**KIRKLEES METROPOLITAN COUNCIL
TOWN AND COUNTRY PLANNING ACT 1990
HIGHWAYS DEVELOPMENT CONTROL KP20H**

PLANNING REF 2014/62/91813/W0/NW
CATEGORY Small Major

PROPOSAL DEMOLITION OF PART OF
MILL,ALTERATIONS TO CONVERT MILL
BUILDING INTO 6 DWELLINGS AND
ERECTION OF 11 DWELLINGS WITH
ASSOCIATED PARKING(WITHIN A
CONSERVATION AREA)

LOCATION HOYLE ING DYEWORCS
MANCHESTER ROAD
LINTHWAITE
HUDDERSFIELD

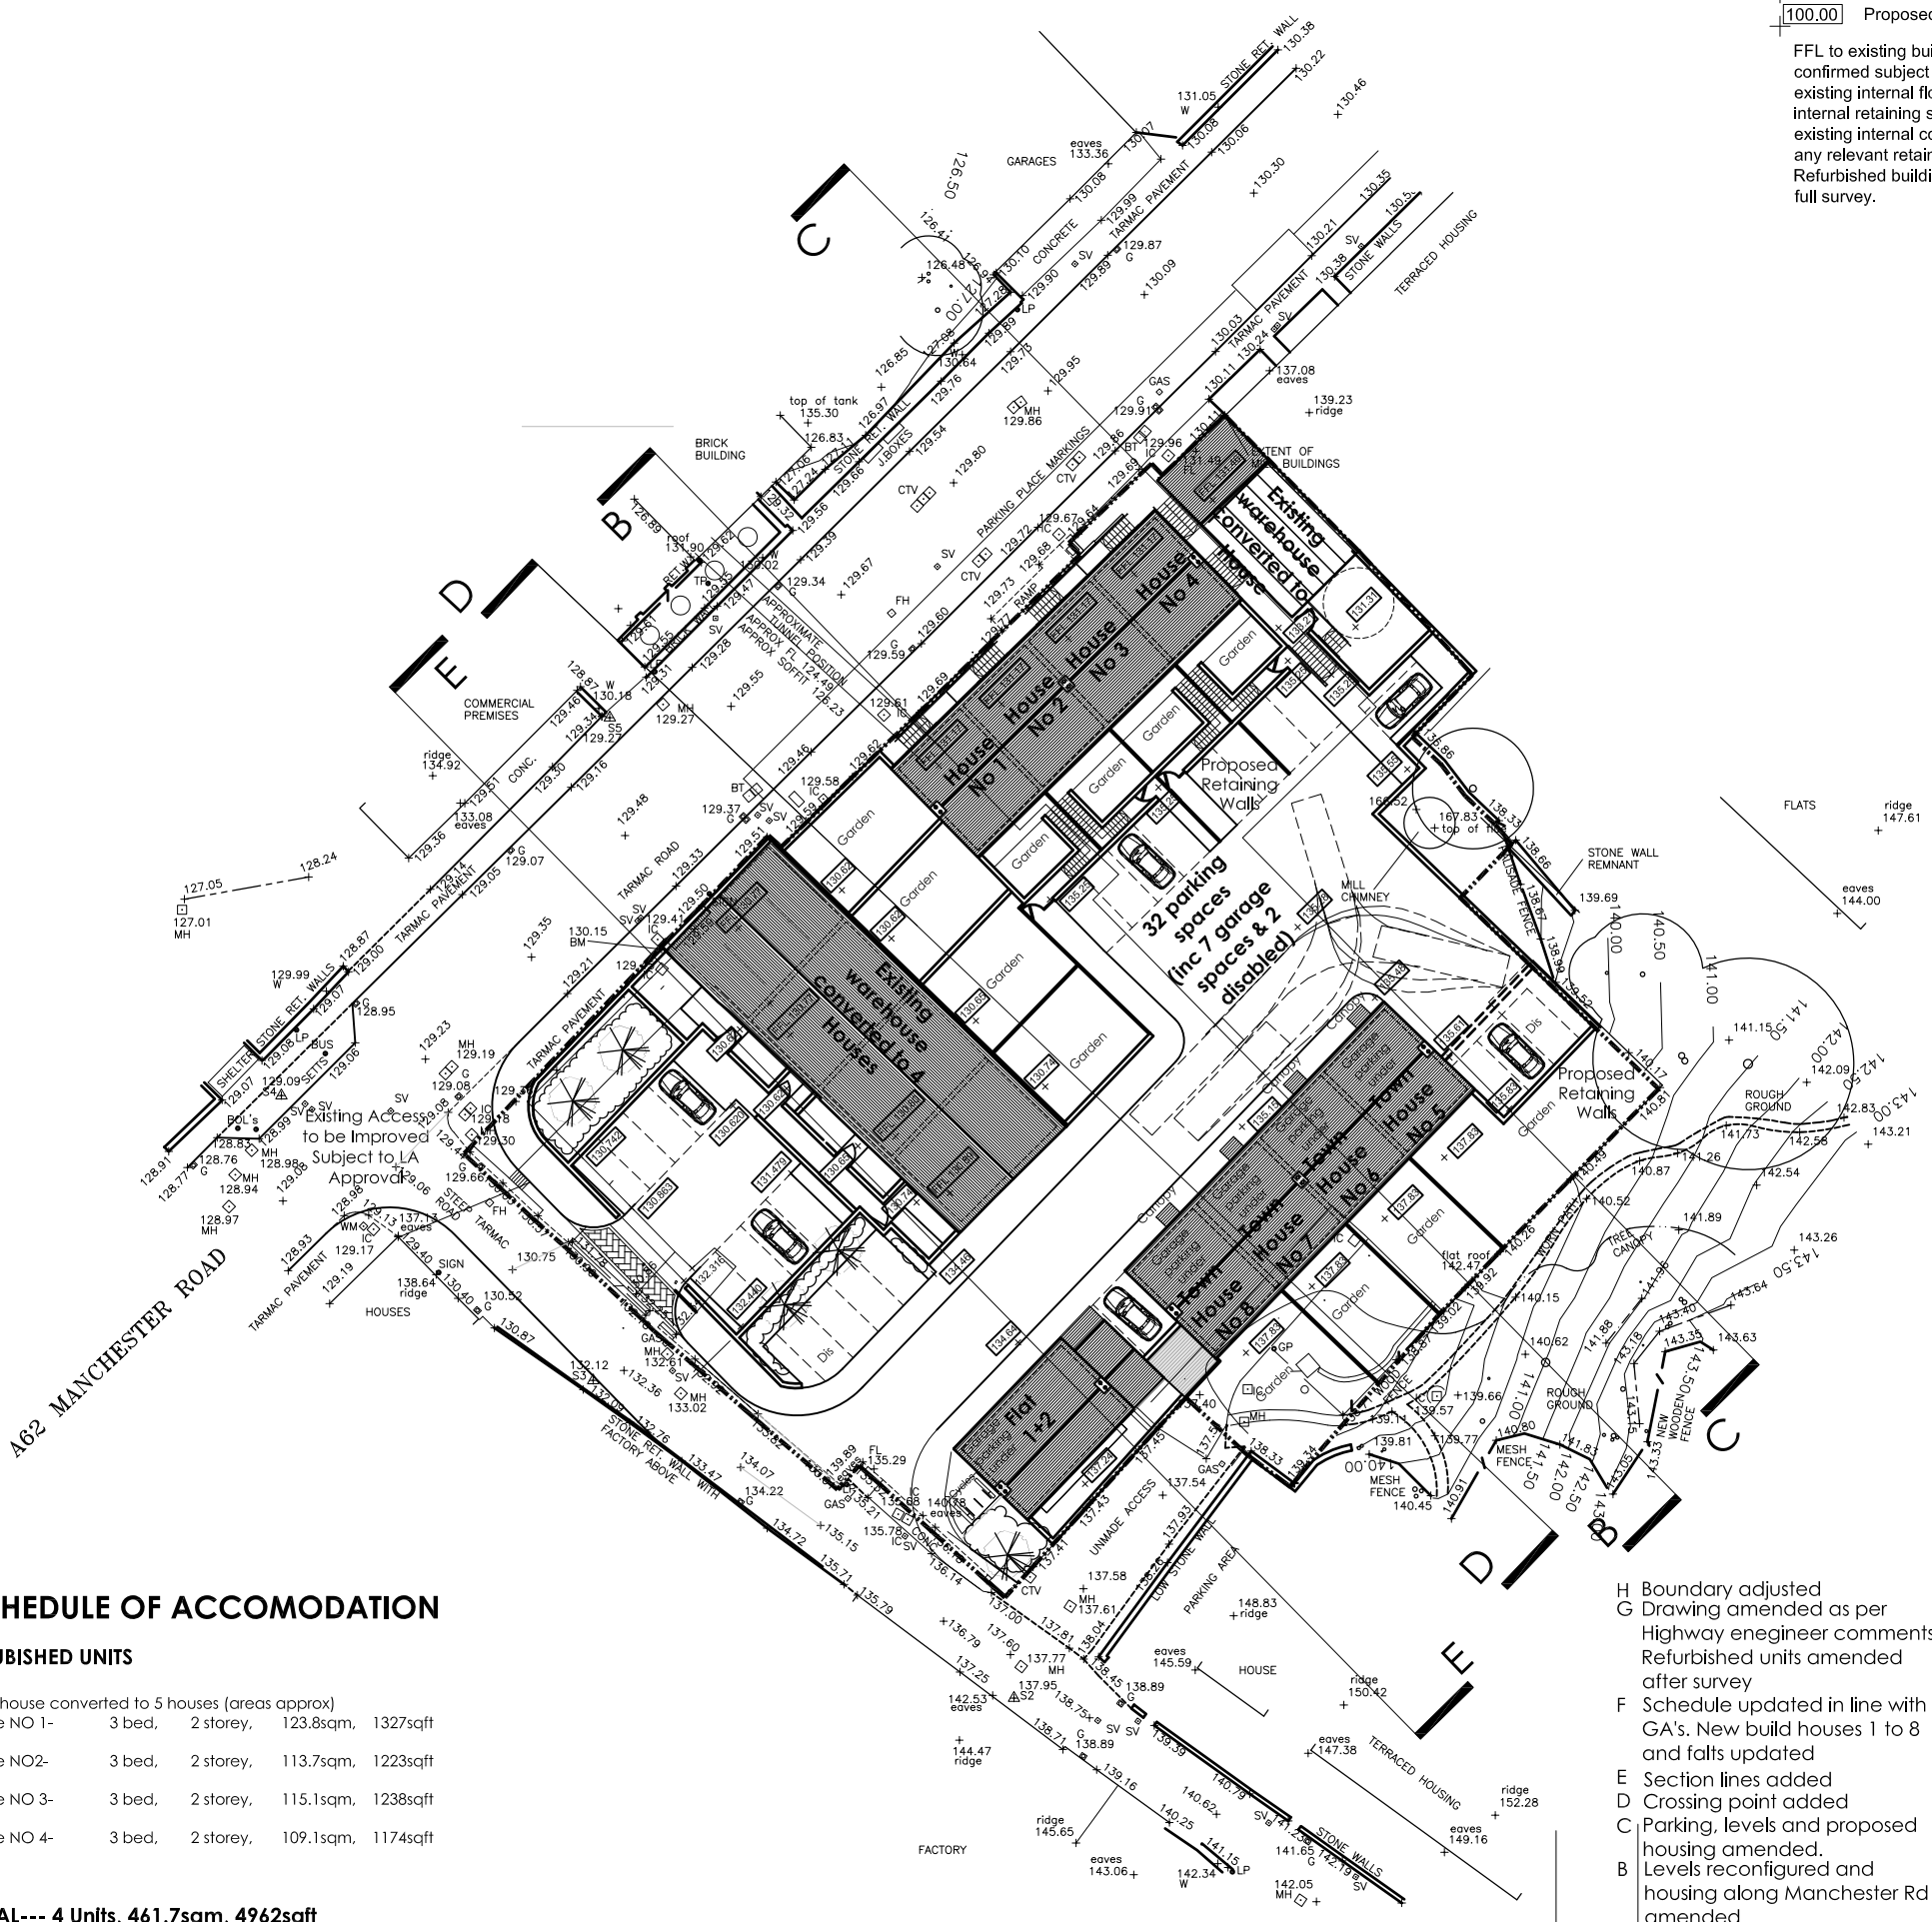
The current application layout drawing J3385/02 Rev A (Dated 05/14) includes 33 parking bays. As proposed it would not be possible to utilise two parking bays at the end of the cul-de-sac nearest to Hoyle Ing nor at the extremity of the second Cul-de-Sac. In addition it would not be possible for users of two parking bays to reverse out since cars parked in the 3 bays nearest to Hoyle Ing would block these moves. To overcome this difficulty the 3 parking bays nearest to Hoyle Ing need to be removed

and the carriageway surface extended by 3m. The footway can be relocated to become nearer to Hoyle Ing.

A similar difficulty exists in the proposed layout of the second cul-de-sac. For similar reasons those 3 parking bays need to be removed, the carriageway extended and a footway re-aligned. The layout drawing needs to be modified to include these alterations and re-submitted.

After modification, the total number of parking spaces reduces to 27. It is noted that the proposed parking bays are not allocated to specific dwellings. In the interests of reducing the potential for neighbour conflicts it is recommended that the revised layout drawing has a parking bay marked such that each dwelling is allocated a space(s) nearest to an individual dwelling. 12 dwellings would each be allocated 2 spaces whilst 3 dwellings have 1 space each.
